The West Midlands Rail Freight Interchange Order 201x

Statement of Common Ground – Canal and River Trust

March 2019

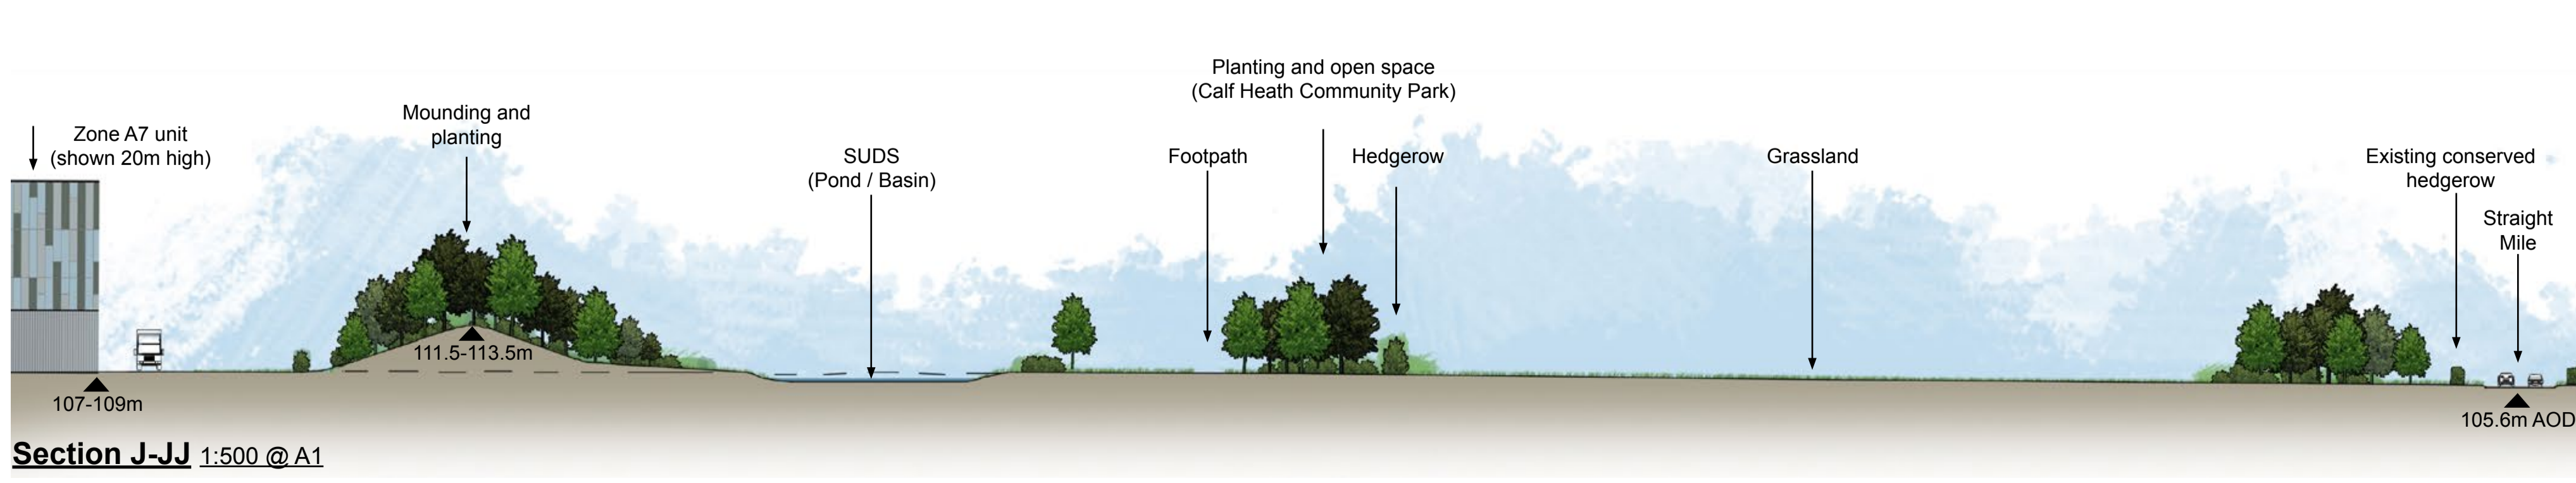
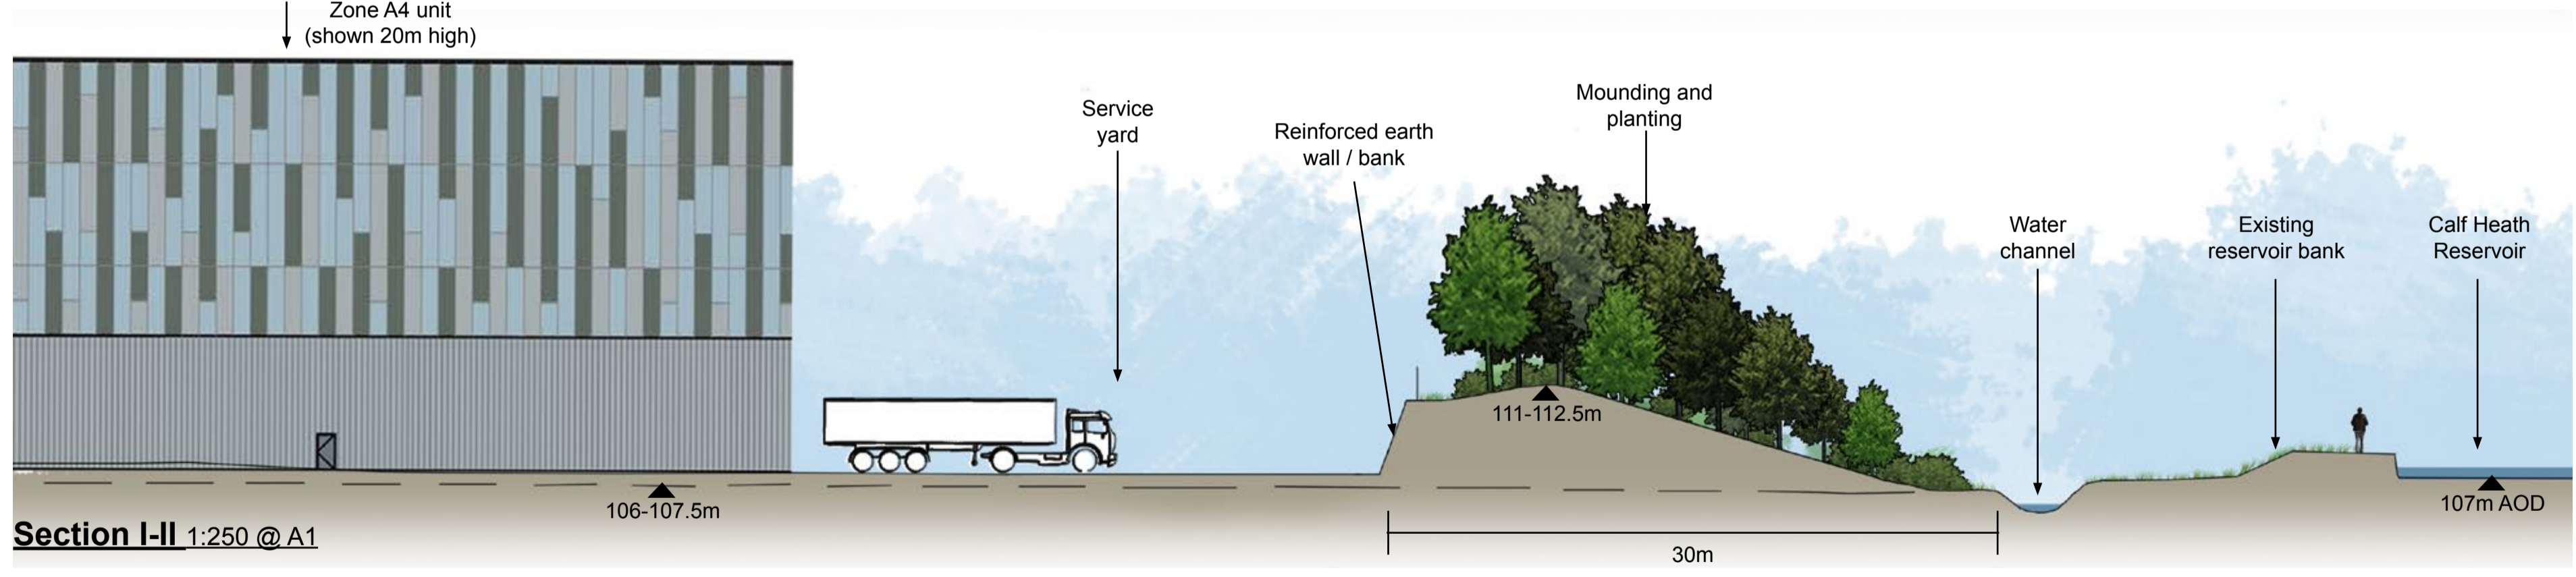
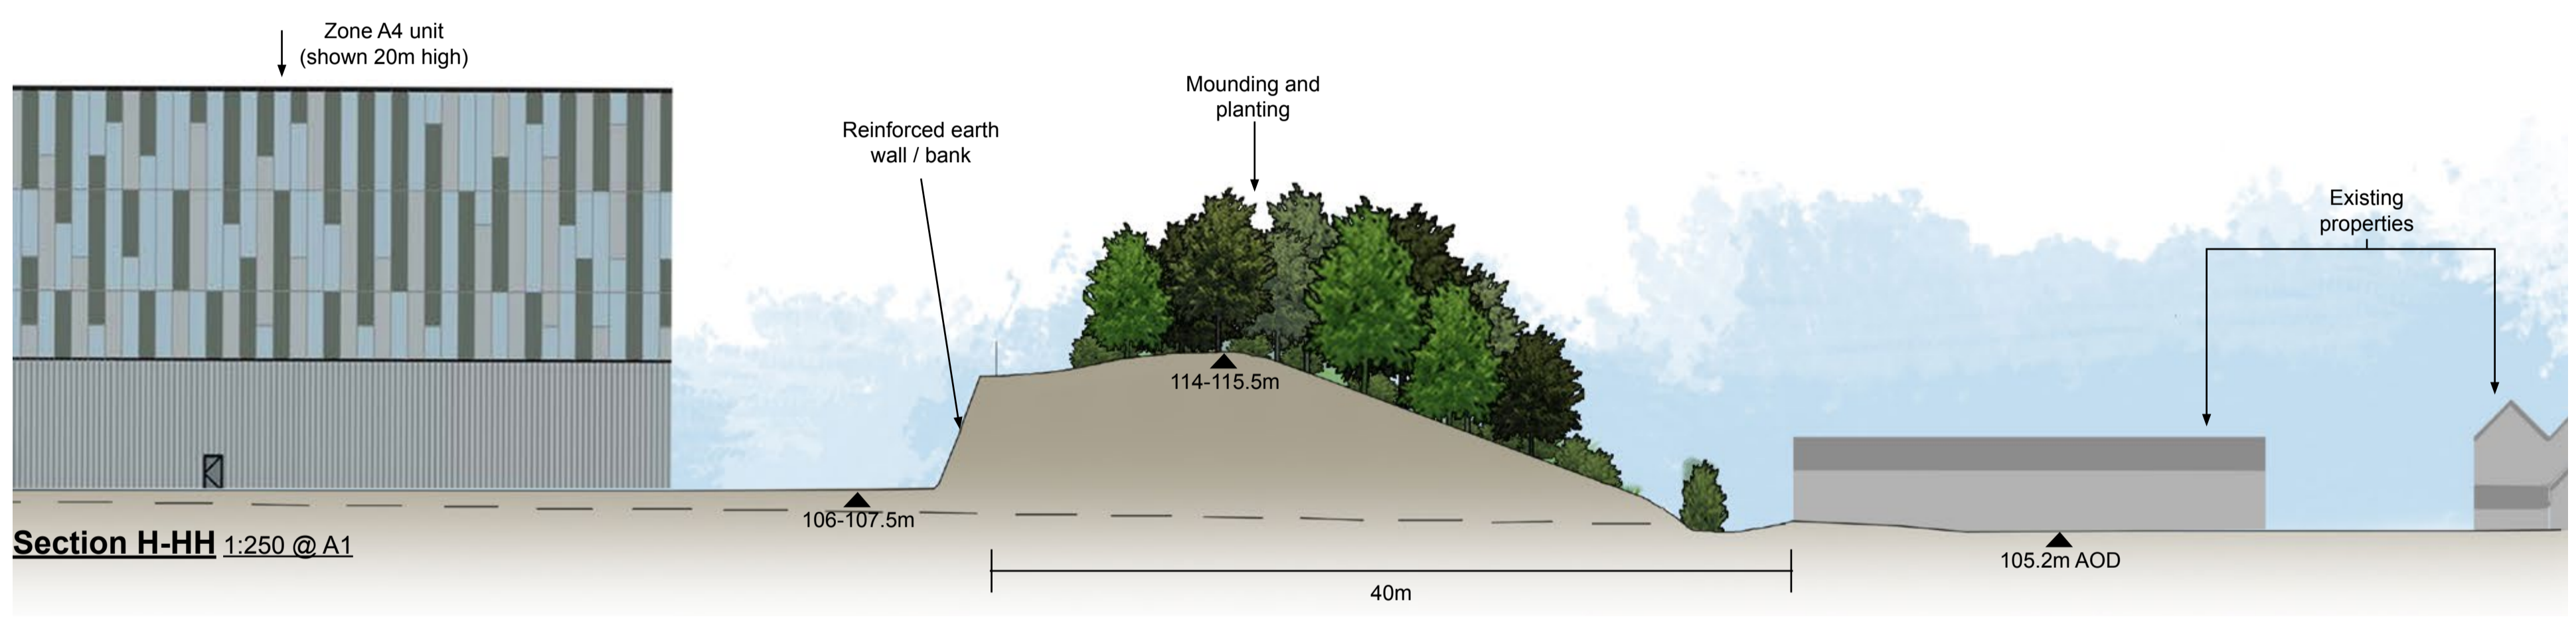
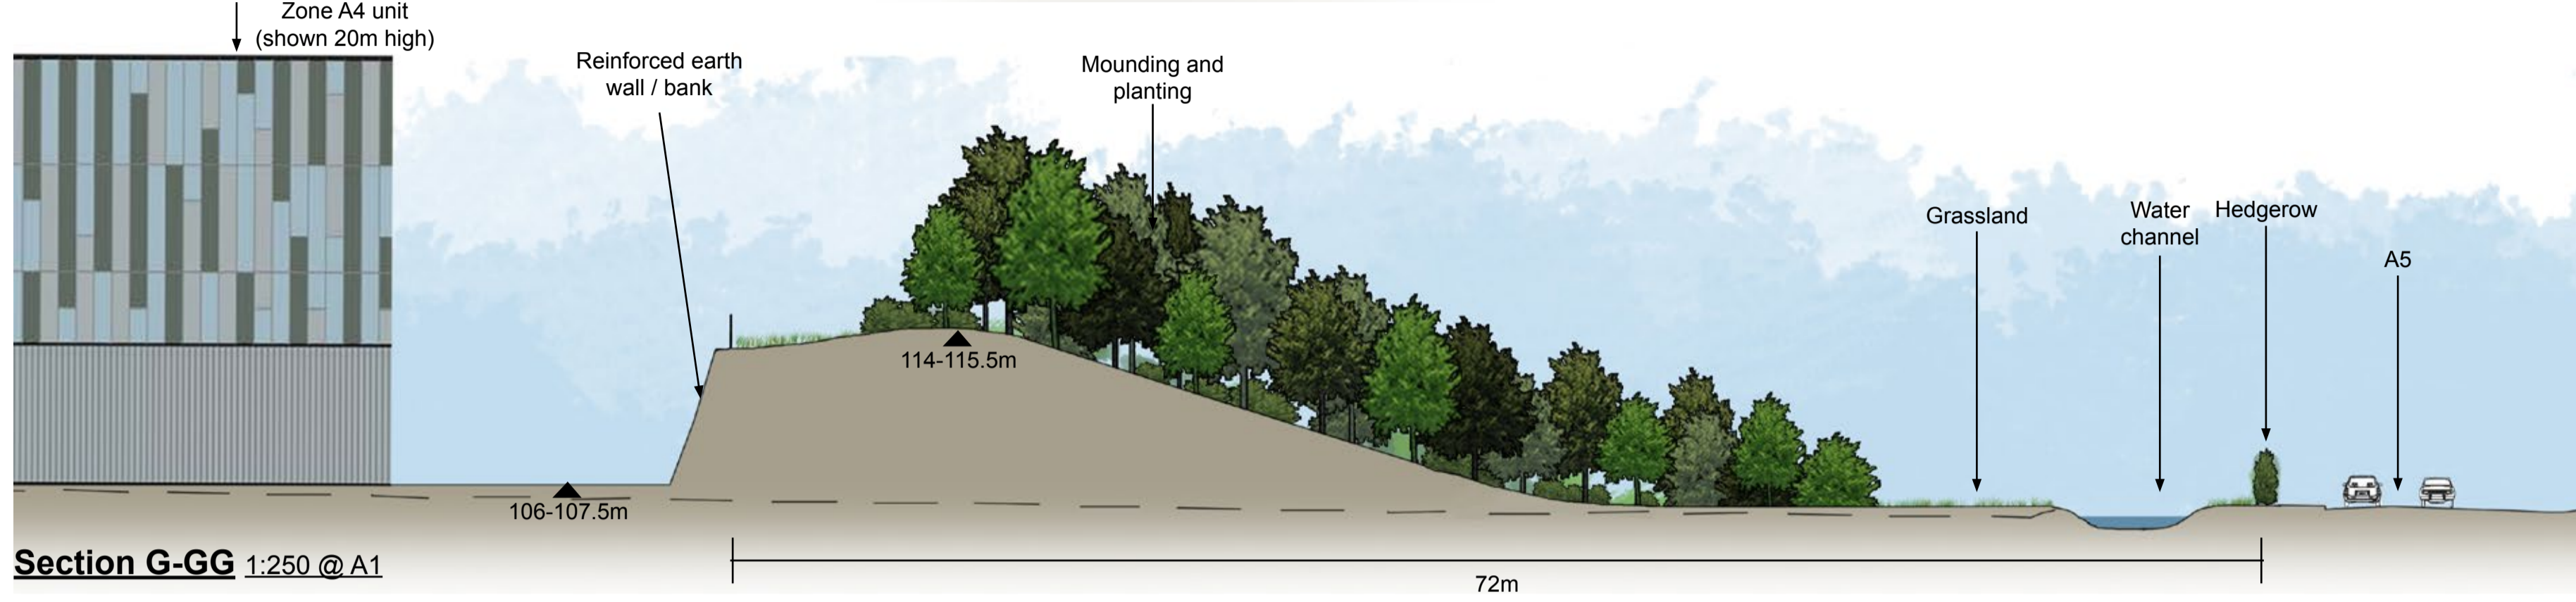
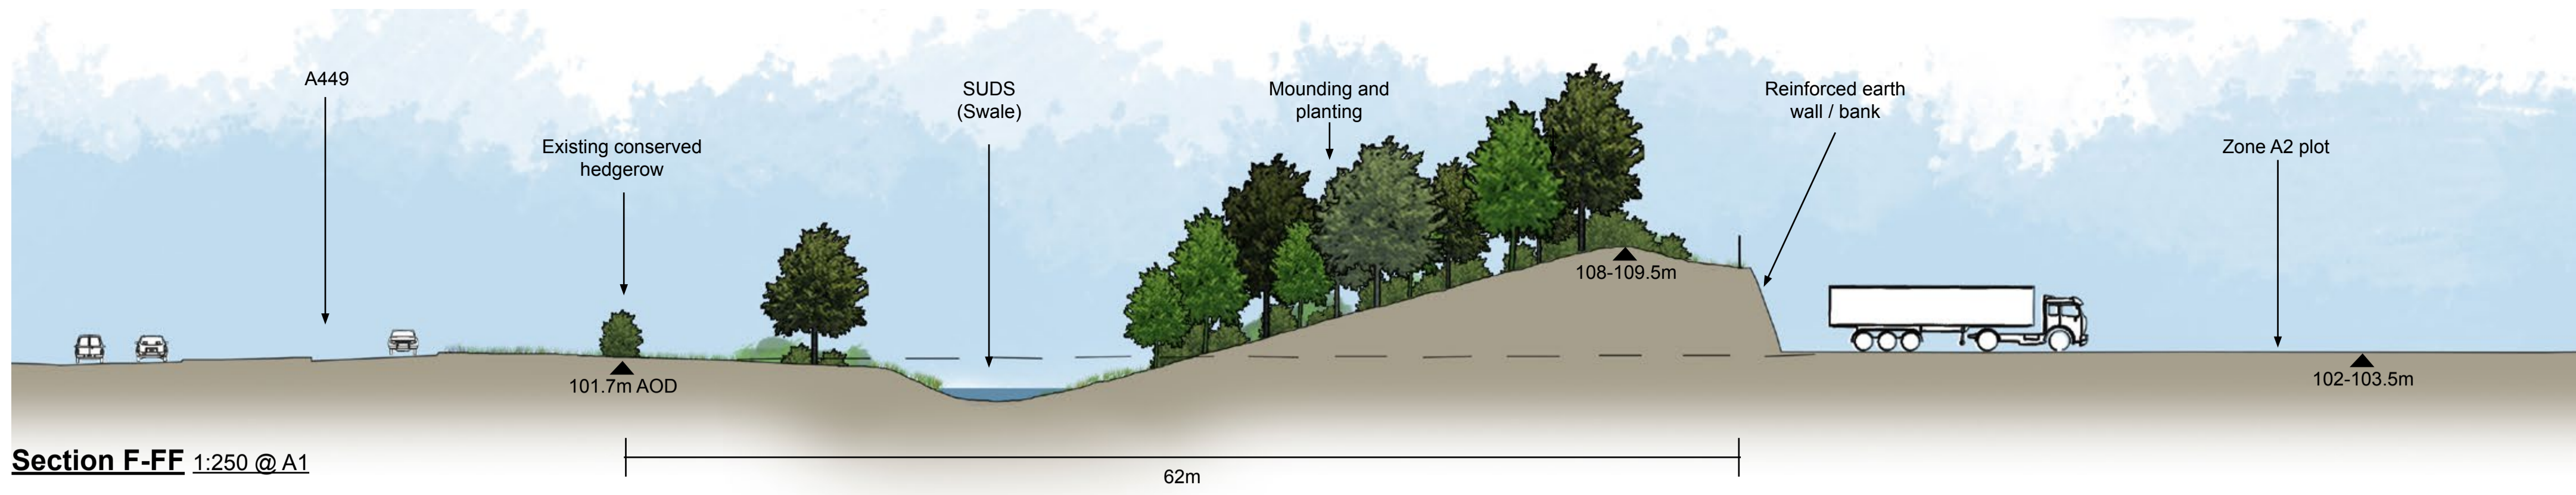
- 4.1.7 To the south of Gravelly Way, development zones are in closer proximity to the Canal (Zones A1, B & C)
- 4.1.8 The design approach for the landscape 'buffer' areas and bunds relating to the Canal and Calf Heath Reservoir are illustrated on the Landscape Cross Sections (Document 6.2, Figure 12.12 – Illustrative Landscape Cross Sections (Sections C-CC; I-II; K-KK; and N-NN));

6.3.3 The Trust consider the heights for the Strategic landscape bunds should be set as part of the DCO and implemented at the start of the development to ensure they become established at the earliest opportunity and the canal is protected from the impacts of the development both during construction and operation of the development from the outset.

6.3.4 The Trust remain concerned that the landscape bunding will be at its narrowest and lowest adjacent to Gailey Marina and the impacts (visual and acoustic) to users of the marina, moorers, canal users (walkers/cyclists, canoe club, anglers etc) has not been fully considered.
